**TOWER 2, LEVEL 23
DARLING PARK, 201 SUSSEX ST
SYDNEY NSW 2000**

10 August 2018

SSD 7419 MOD 1 | AUSTRALIAN HABITAT AND WILDLIFE RETREAT | RESPONSE TO SUBMISSIONS REPORT

02 SECTION HH' - TARONGA CENTRE STAGE 1 WORKS
1:100

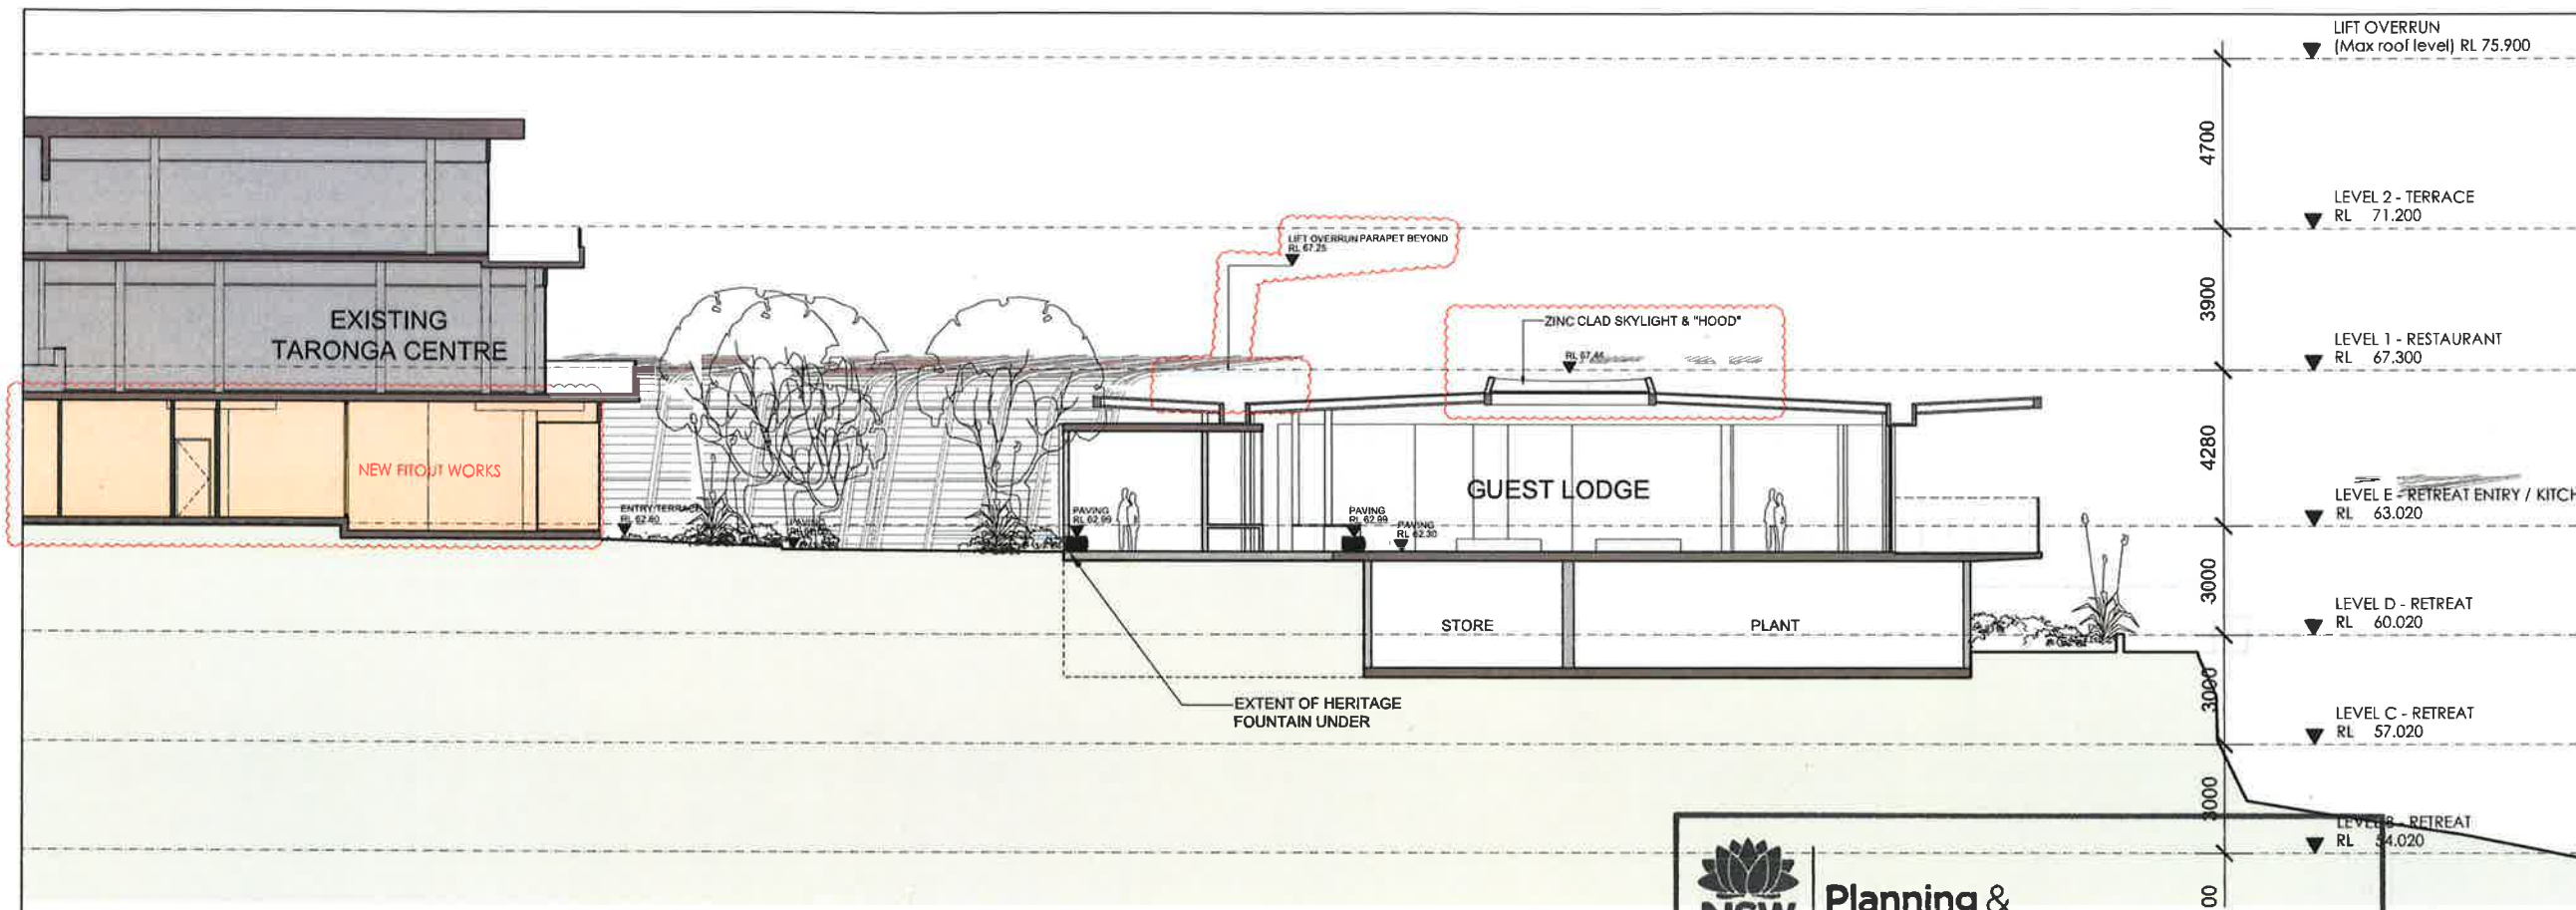
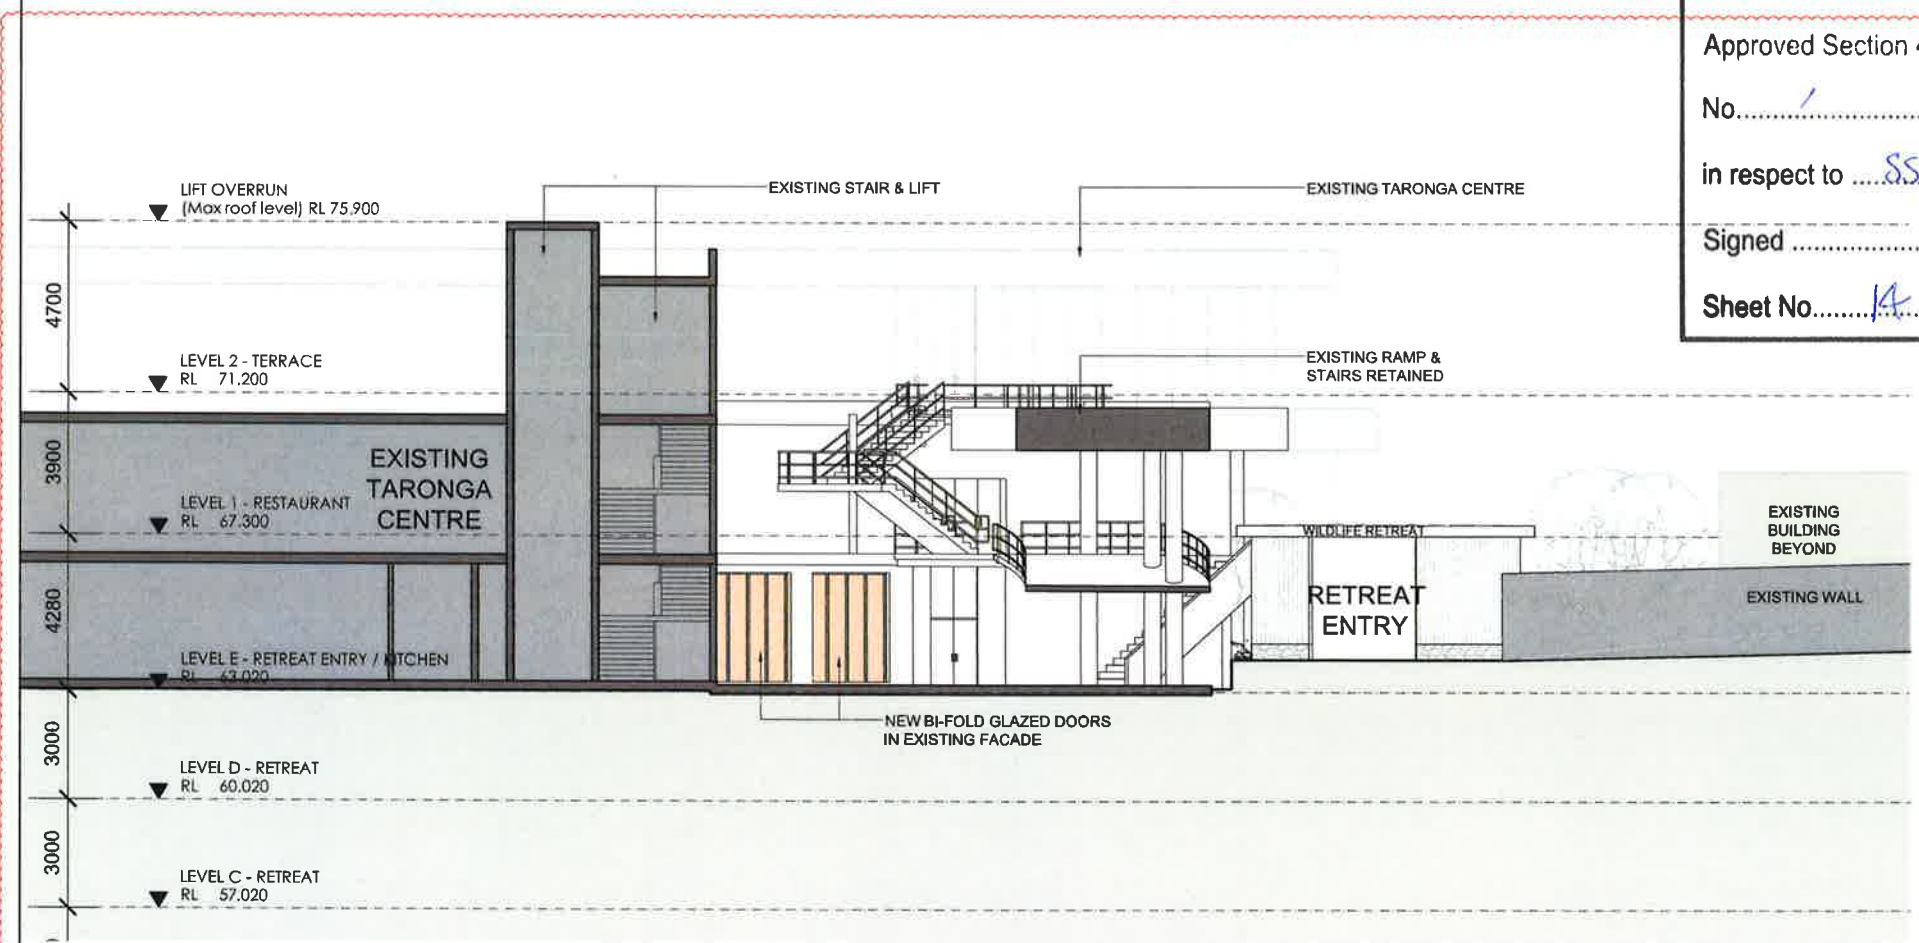
The Department have requested clarification on the nature of, and identification on a plan, the 'external changes to the Ground Floor of the Taronga Centre to provide additional windows and access'. These changes are illustrated on drawing number AR-DA-2105A and AR-DA-4104. The additional window is located behind the Wildlife Retreat Entry on the Entry Elevation AR-DA-3801 and as such it is not visible from the public domain.
